PLANNING CONSULTATION RESPONSE

Application No	2026/0685
Proposal	2026 0685 Erection of Detached Dwelling (Use Class C) with Associated Works Including Parking and Landscaping Land Adj Berry Fold Cottage Berry Lane Howbrook
Address	Land Adj Berry Lane Cottage Berry Lane
Date of Consultation Reply	090926
Consultee	Tony Wiles Senior Conservation Officer

Drawing No. HB-PA-001		Revision 0000	
Drawn DBC	Checked -	Paper Size A1	Scale 1:200 / 1:500
Date 15/10/2025

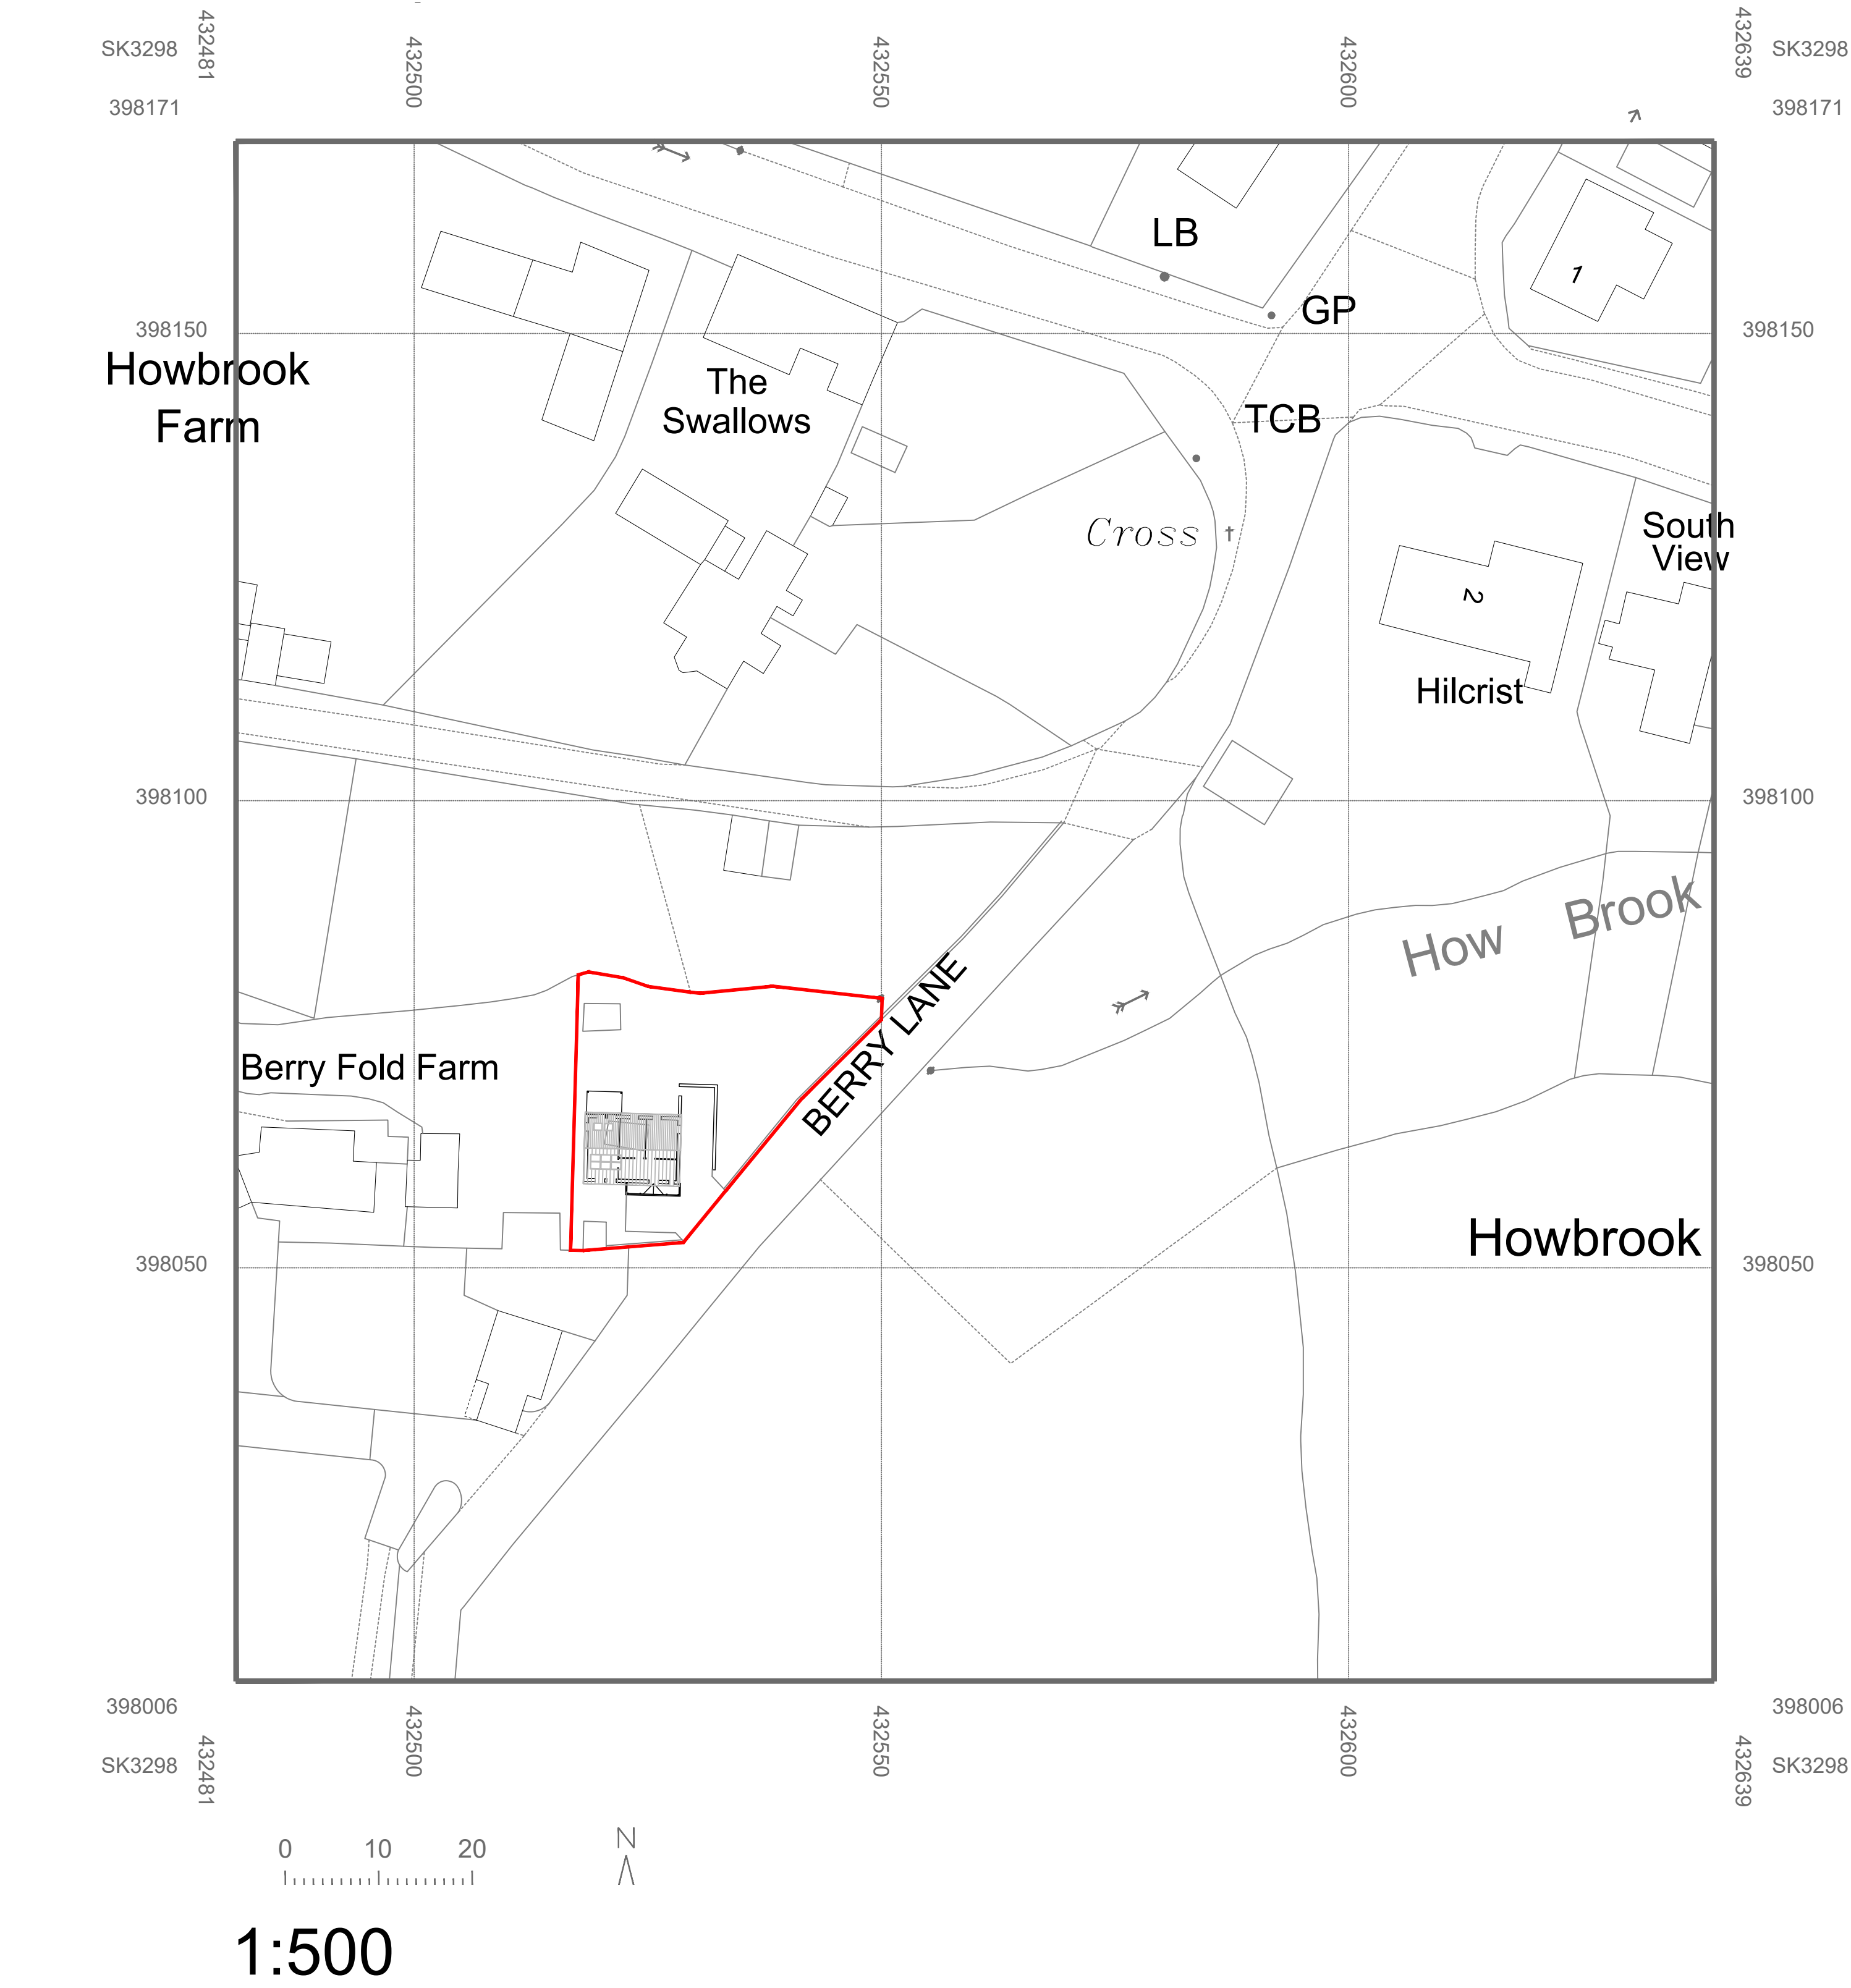
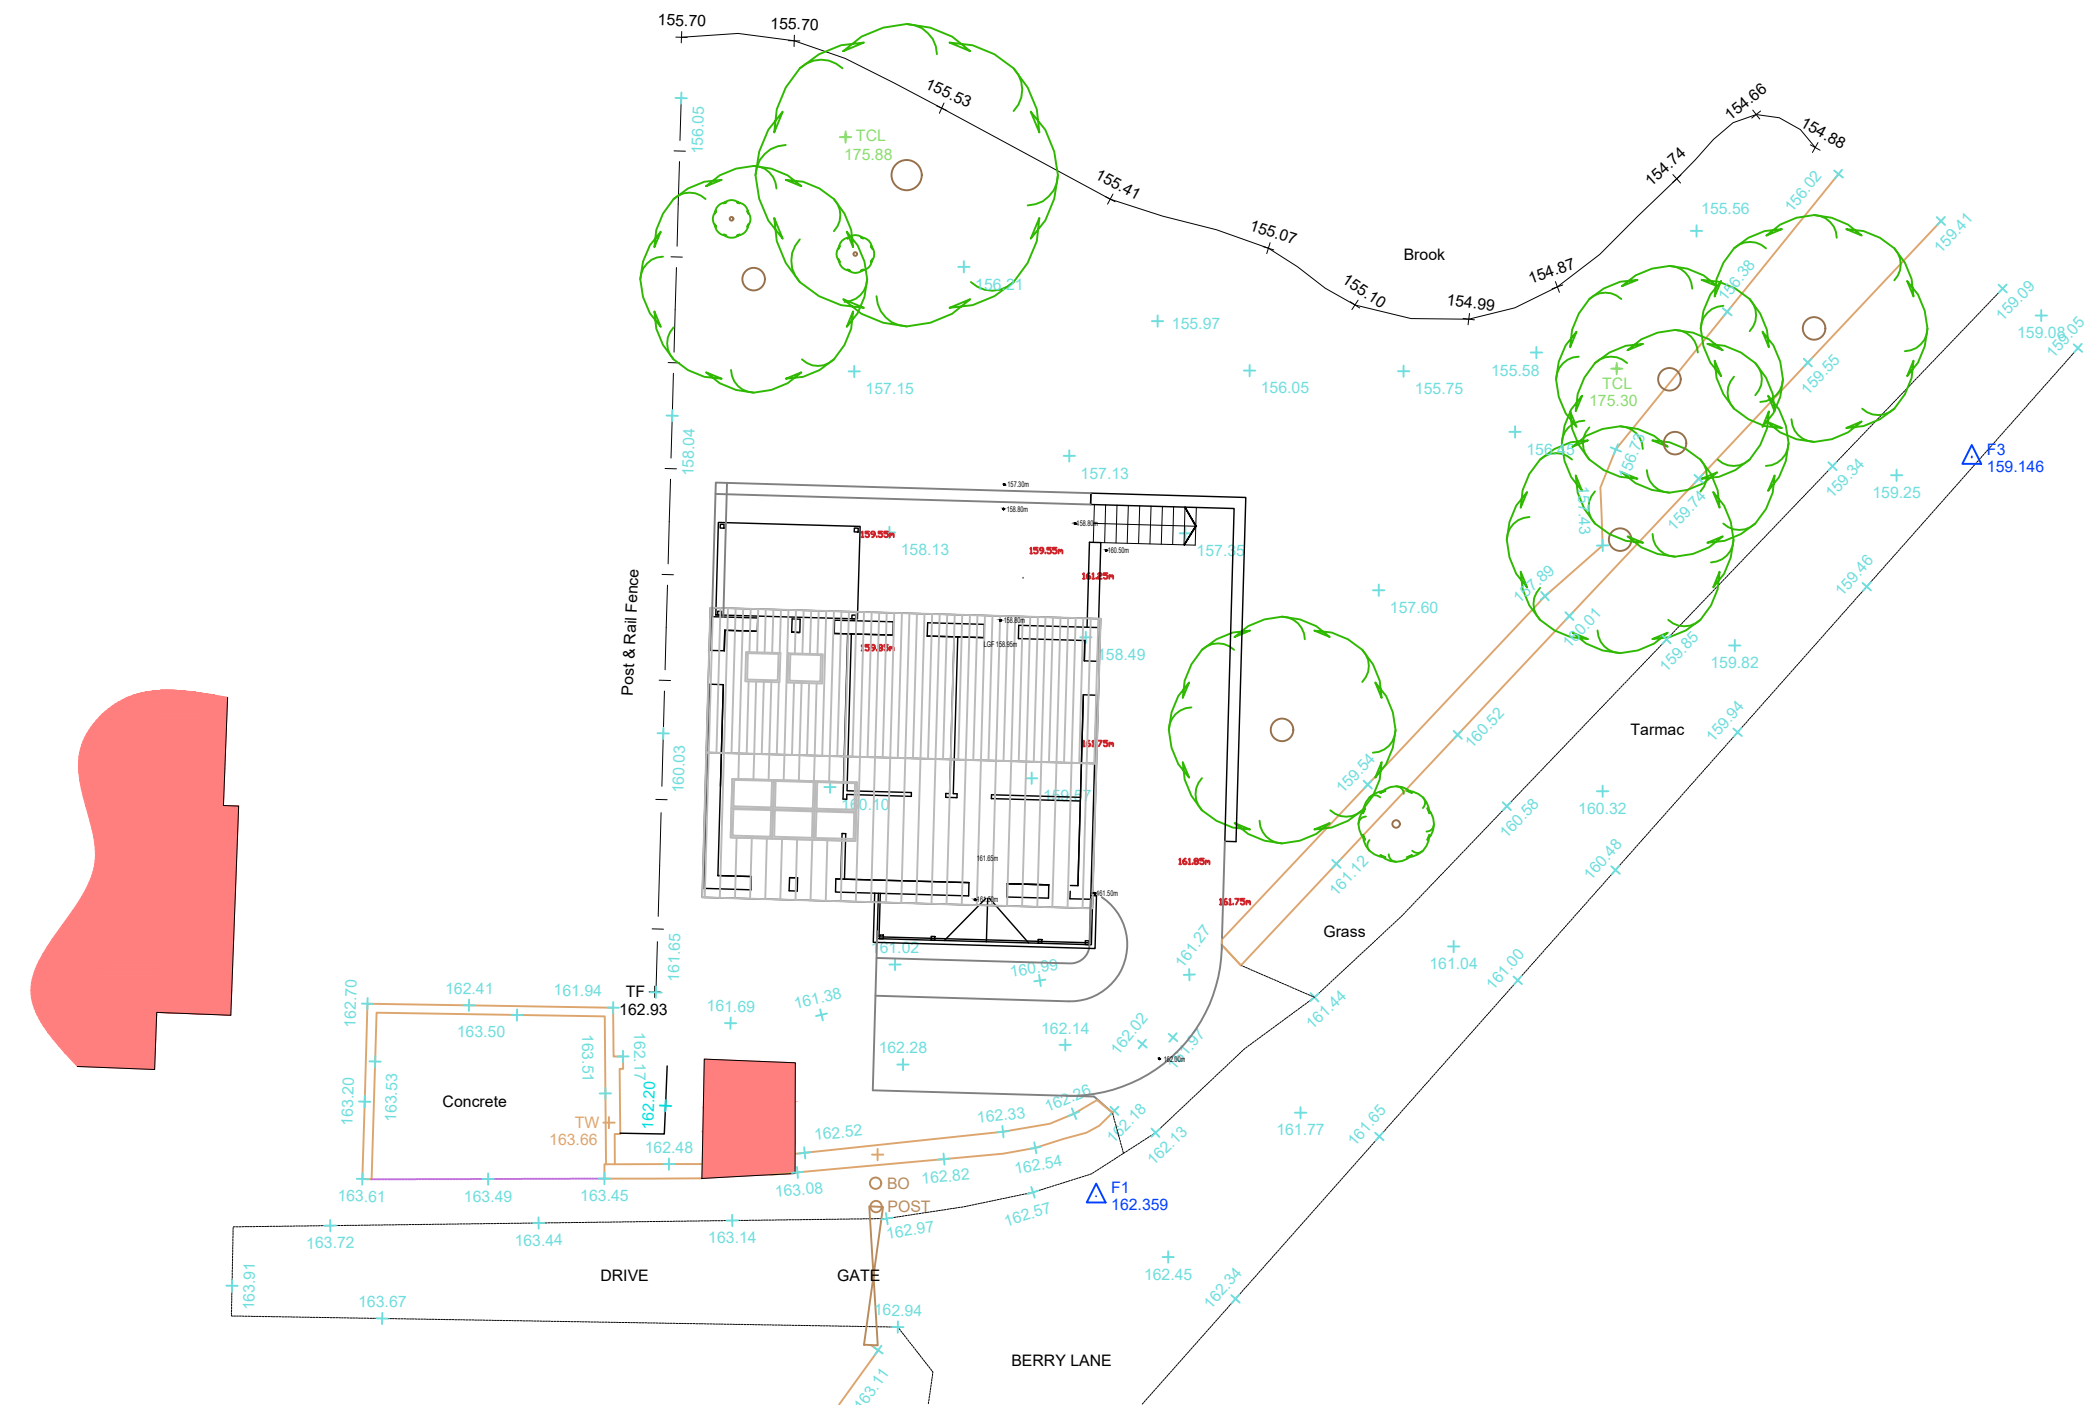
The proposal may require the demolition of the small roadside structure, which appears to have originated before 1851, with its existing relationship and plan form established by the 1891 map and broadly surviving today. The building is partly stone, with side elevations in red engineering brick, and appears to be a fragment of an ancillary building associated with Berry Fold Cottage. Clarification is required as to whether demolition of this structure is actually proposed, as the landscape plan appears to show retention of a red structure but provides limited detail on what this represents.

Drawing No.
HB-PA-002

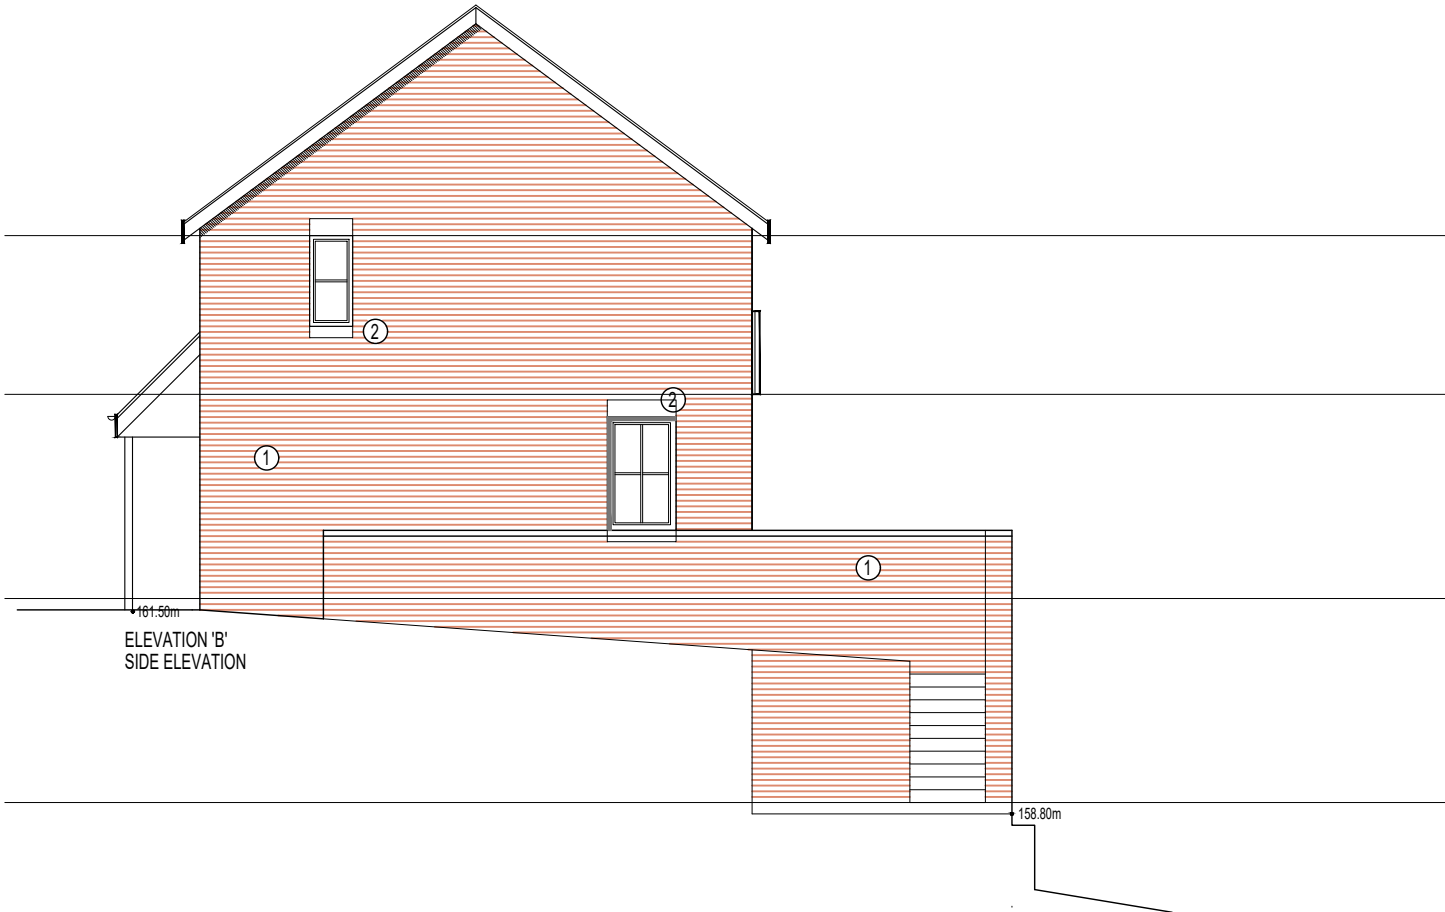
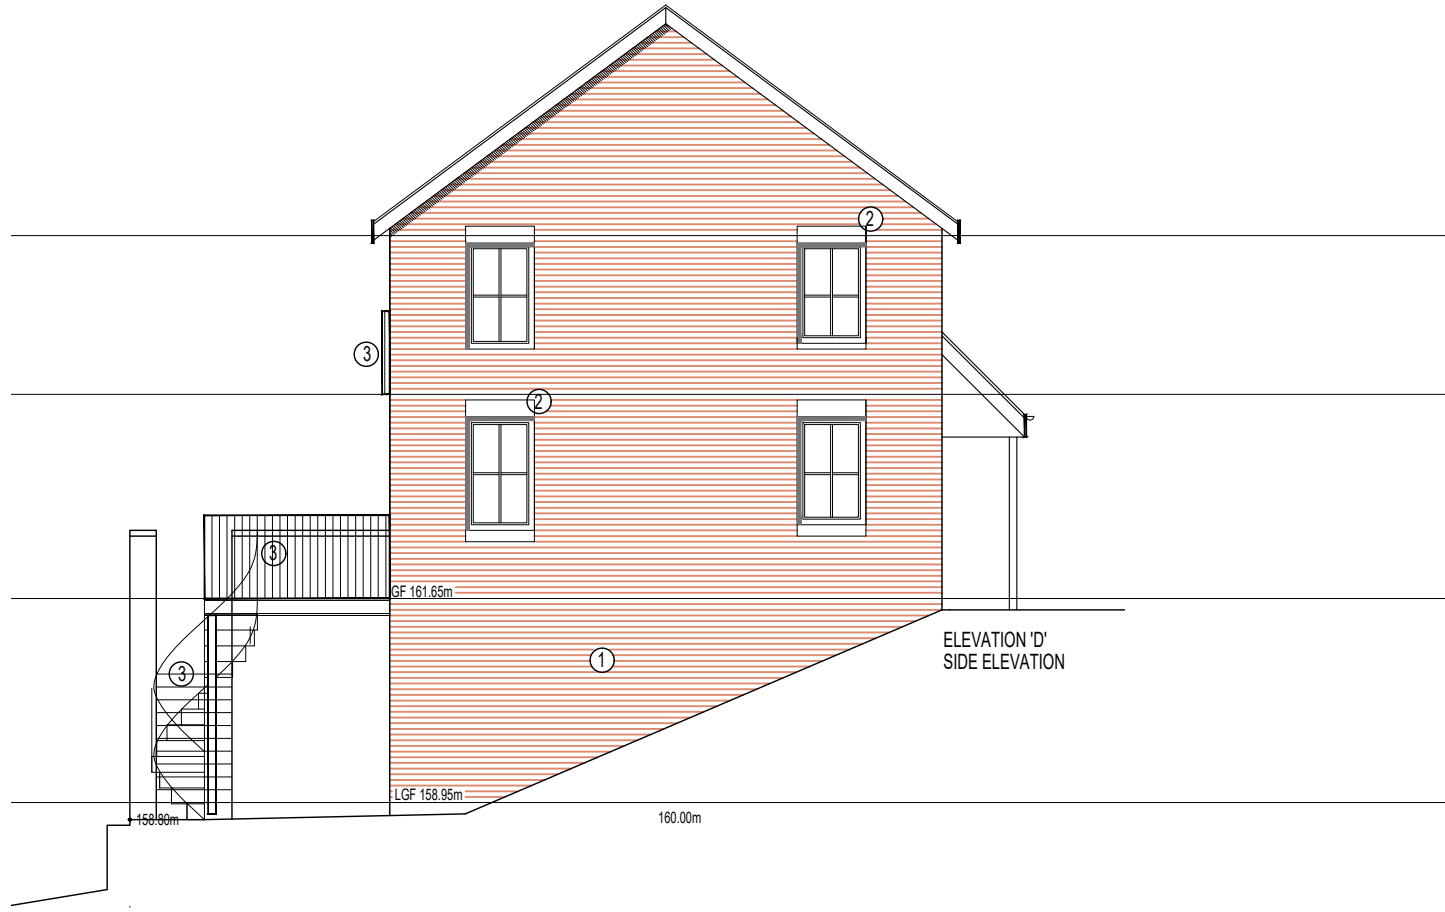
I also note the liberal use of large rooflights or patent glazing, which appears somewhat out of keeping with the historic and traditional character of the setting. These elements would be more sympathetic if reduced in number, broken up into smaller units, and specified as conservation rooflights: black, low-profile units with a single vertical glazing bar and a vertically emphasised proportion.

The front elevation is appropriately restrained. The rear elevation includes some details which are less characteristic of the local vernacular, including a Juliet balcony, a walk-out balcony, and several full-height glazed openings. However, this part of the building would not be fully visible from the public realm, with only side and oblique views likely to be available. On that basis, some relaxation of a strictly traditional approach to the rear elevation is considered acceptable.

ELEVATION A'
FRONT ELEVATION

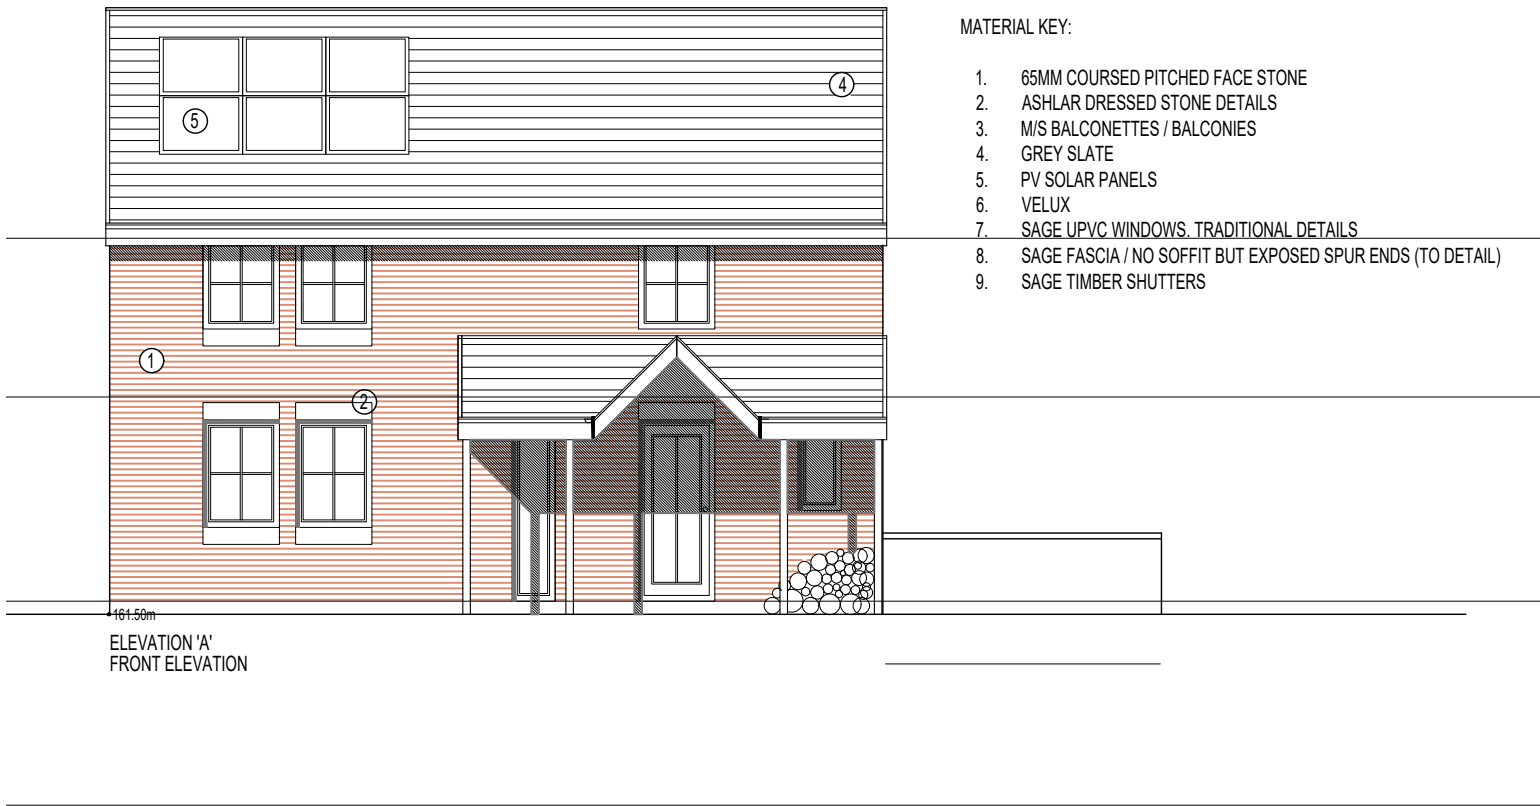
I do, however, have concerns regarding the canopy over the front door. Its offset and open form reads as a distinctly modern intervention and does not sit comfortably with the otherwise traditional character of the neighbouring historic properties. A simple pitched canopy, with the roof set just below the first-floor window and supported on timber or oak framing/posts, would provide a more sympathetic detail.

Finally, I am aware that neighbouring buildings, including the garages erected under application 2011/1079, incorporate quoins to the wall corners. This detail adds a degree of architectural character and gives new development in this setting a more authentic and convincing appearance. I would therefore suggest that quoins are also incorporated into the current proposal.
